CITY OF ALBUQUERQUE

August 4, 2015

**Re: The Jones Home
9000 Alameda NE
Grading and Drainage
Engineers Stamp Date 7/22/2015 (C20D073)**

GRADING & DRAINAGE PLAN

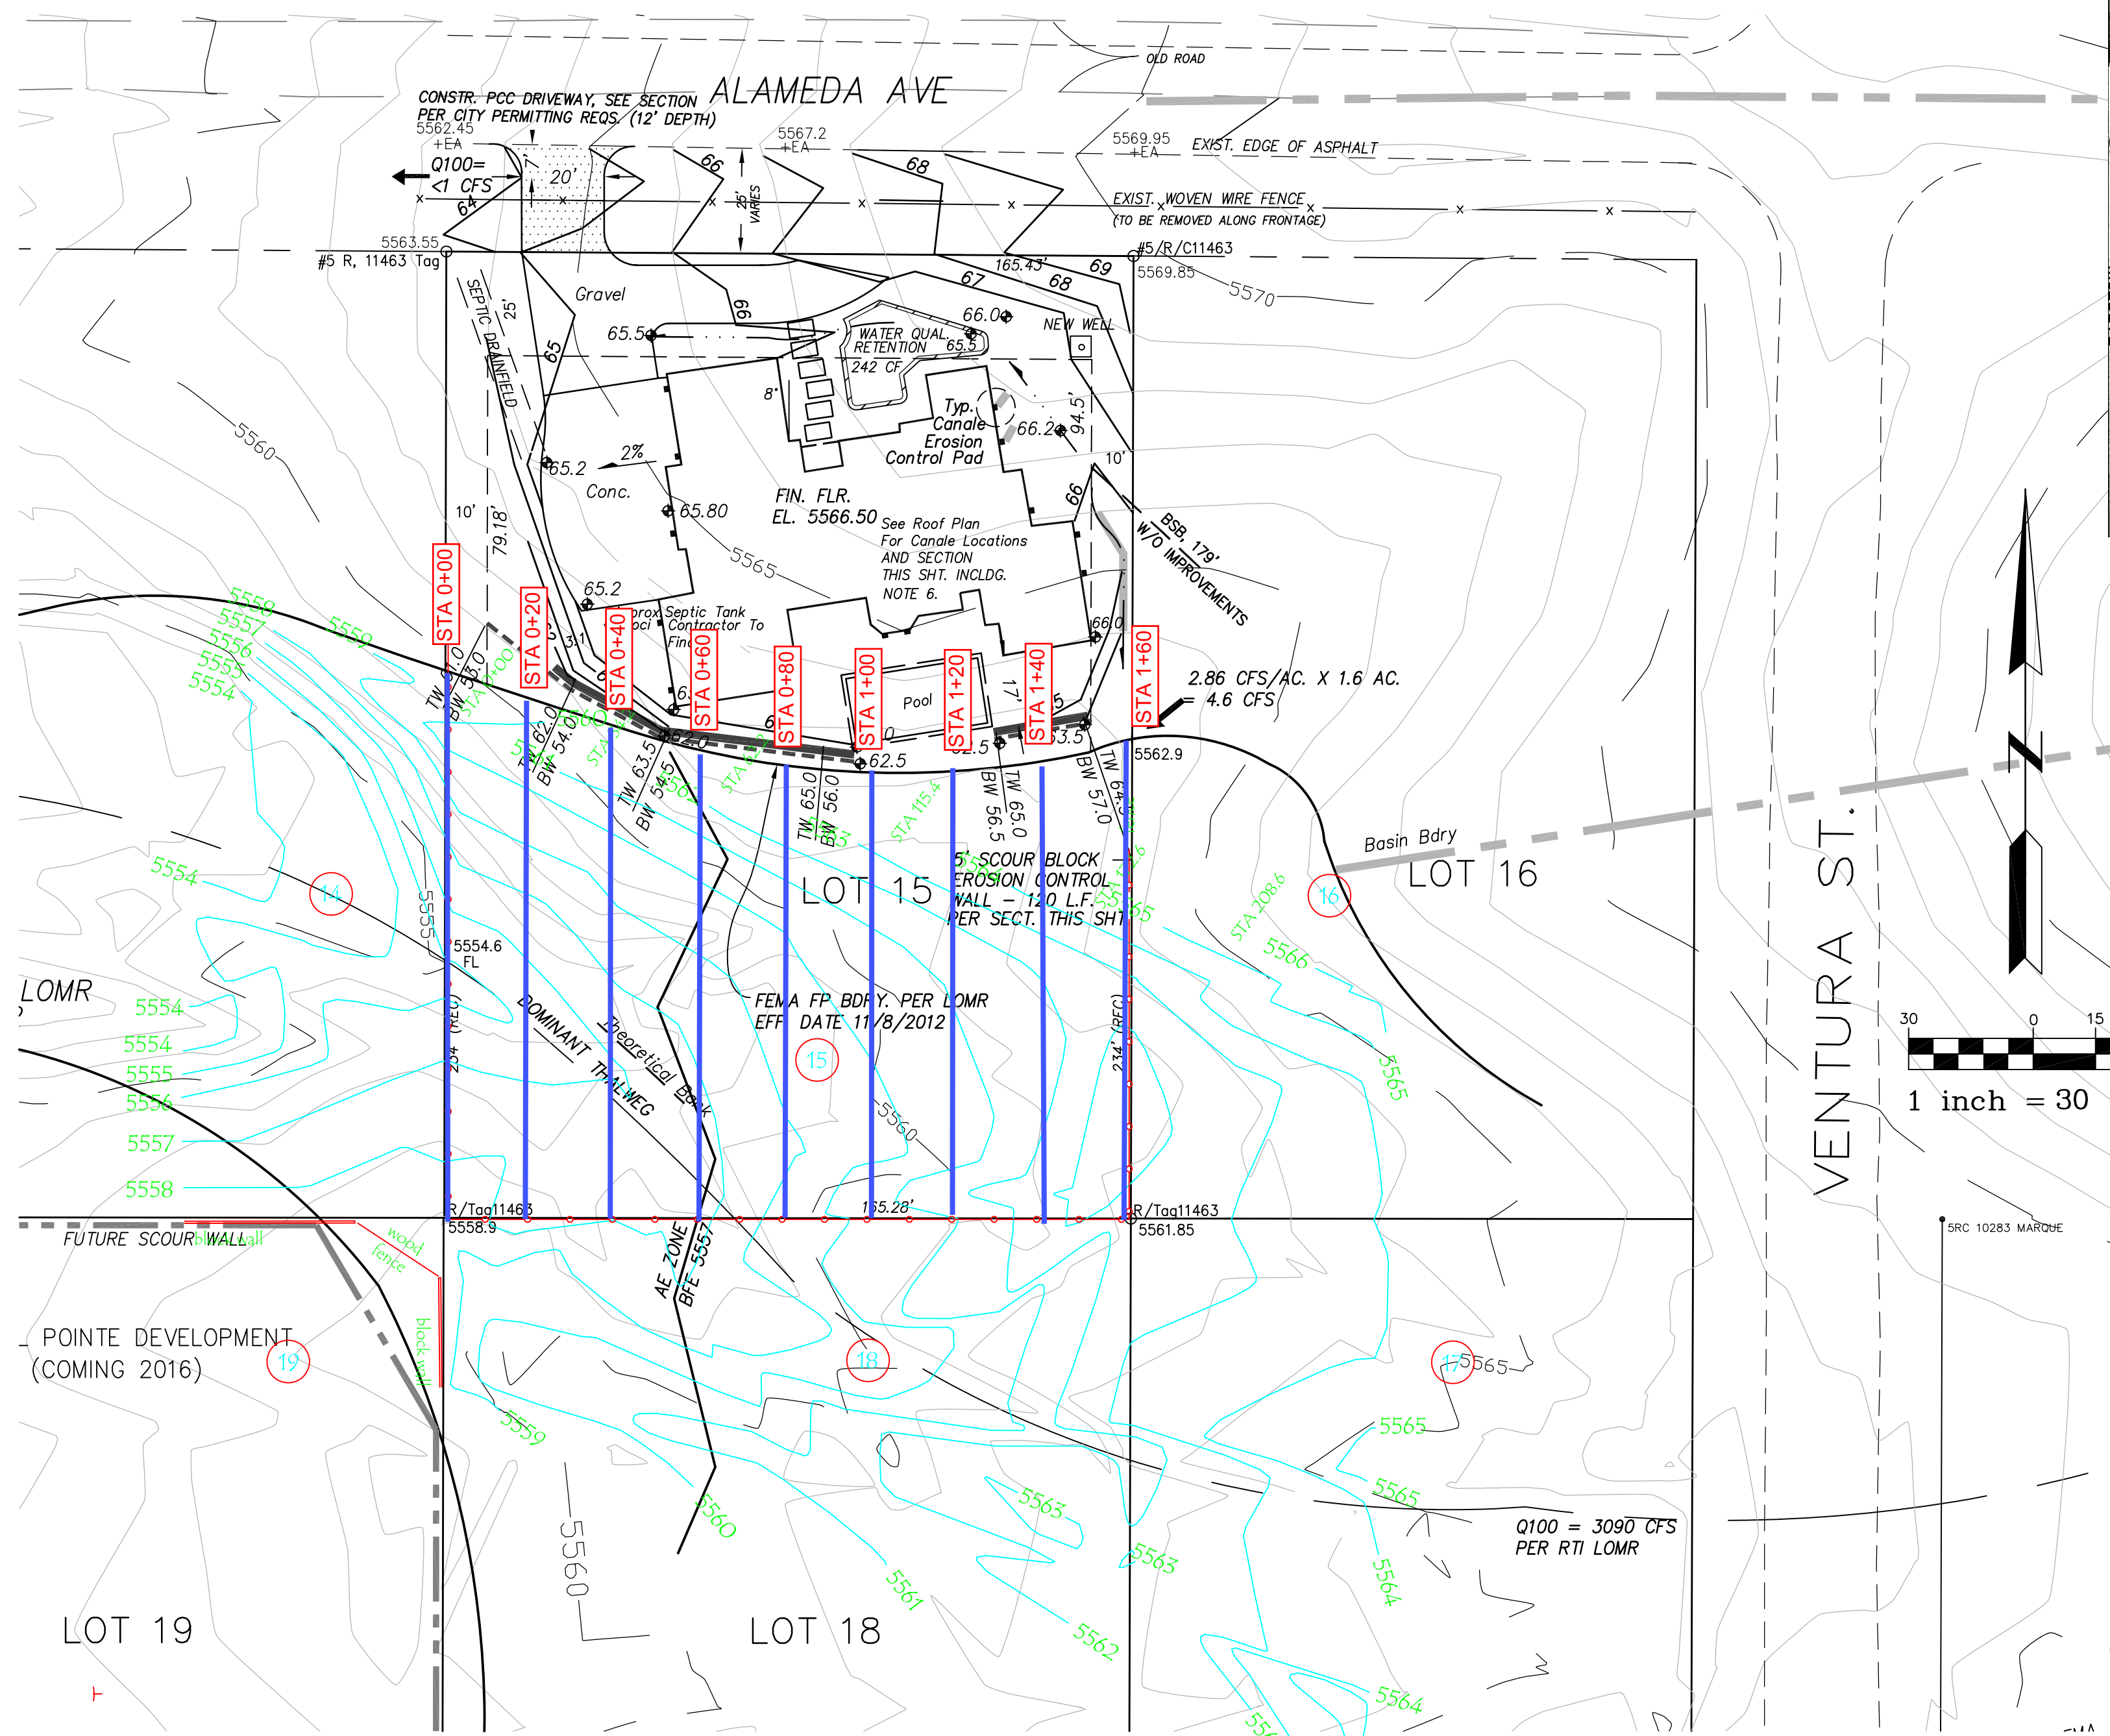
- Provide the "First Flush" calculations and Ponding for the new impervious area's.
- Provide a basin for the 2cfs.
- A Floodplain Permit will be required before any construction begins.
- Provide roof flows.
- The scour wall to the west of the home needs to protect the septic tank and septic drain field.
- Provide the flow amount coming from Alameda Blvd. and Ventura St., headed in a southwesterly direction into the AE flood zone, if any.
- The two flood control structures provided are not acceptable. In option B the block should extend below the scour depth.
- The driveway must be concrete, provide a detail as to how the driveway will not block the 2cfs flow.
